Office of
Environment
& Heritage

Our ref: DOC18/644883
Your ref: MP08_0098 MOD13

The Star City Casino – 20-80 Pyrmont Street, Sydney (MP08_0098 MOD13) – Environmental Assessment

The Star City Casino – 20-80 Pyrmont Street, Sydney (MP08_0098 MOD13) – Environmental Assessment

Figure 5. 3D model of proposed new vehicle entrance on Pyrmont Street

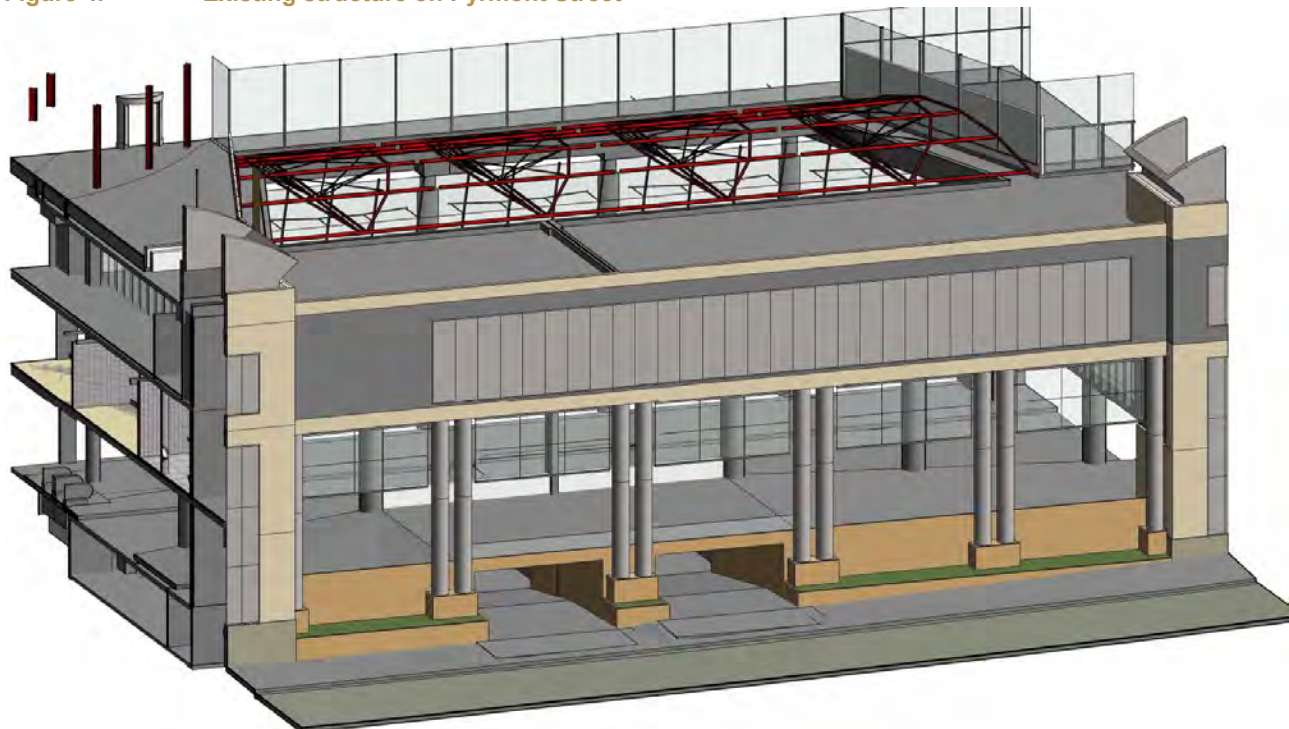
- The planning proposal includes a new vehicle access on Pyrmont Street
- The updated modelling is acceptable and shows a decrease in flood inundation at Pyrmont Street.

- As stated in Section 6 table 11, the Flood Planning Level for Below Ground Parking is the 100 year ARI flood level +0.5m
- Planning levels such as the above are normally only applied to flooding above 100mm (confirmation with City of Sydney should be sought on this). Therefore, the planning level at the new vehicle access should be the level at which at least 100mm of flood occurs plus the 0.5m. Interpreting the report the flood planning level at the Pyrmont Street vehicle access would be 7.01m (6.51 + 0.5m). Confirmation on this level should be sought from the City of Sydney.

- If City of Sydney confirms the new flood planning level at this location and protection is required a flood gate is proposed. Further details on the flood gate need to be provided including:

- How would this flood gate operate?
 - Would it be automatic or manual?
 - Who is responsible for the operation of the gate? etc.

The design is not compliant until the exact details of how the flood gate will operate is shown.
